**SSD 12_5676 AND SSD 12_5677 – MIXED USE COMMERCIAL DEVELOPMENT – 6
AUSTRALIA AVENUE AND 2 HERB ELLIOT AVENUE SYDNEY OLYMPIC PARK**

The applications have been reviewed by the Sydney Olympic Park Authority (SOPA) and are considered to be largely satisfactory. The following comments and suggested conditions of consent are made in response:

drawing title  
Ground Floor Basement Access & Loading Dock  
Access

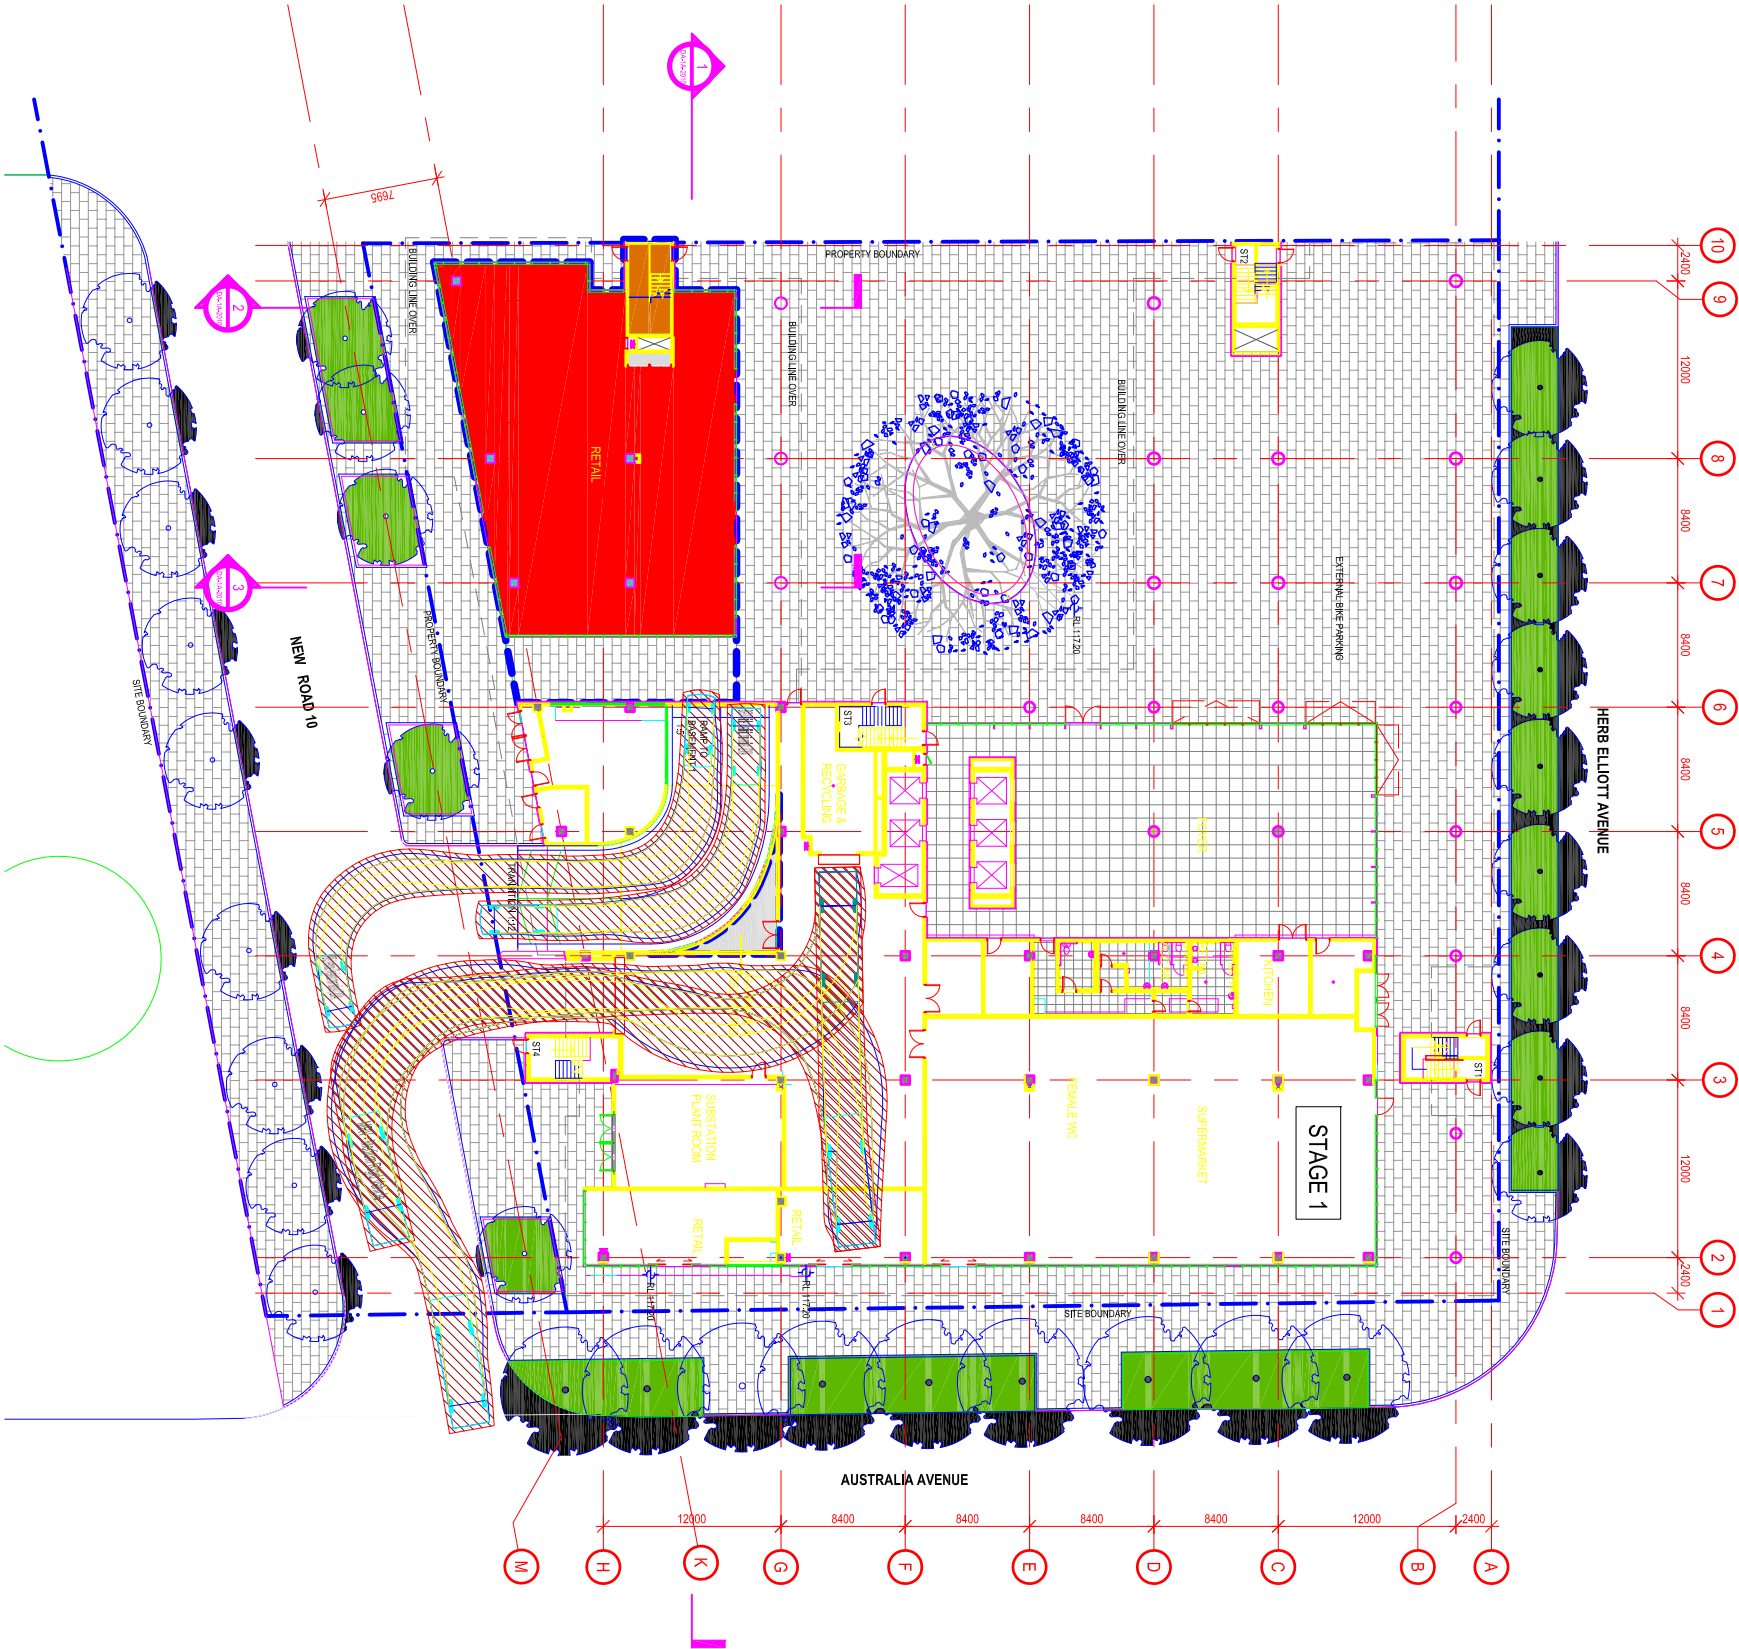
To address potential conflict between passenger vehicles, trucks and pedestrians all vehicles entering and exiting the loading area from Herb Elliot Ave must do so in a forward direction.

4. All vehicles entering and exiting the Loading Area from Herb Elliot Ave must do so in a forward direction.
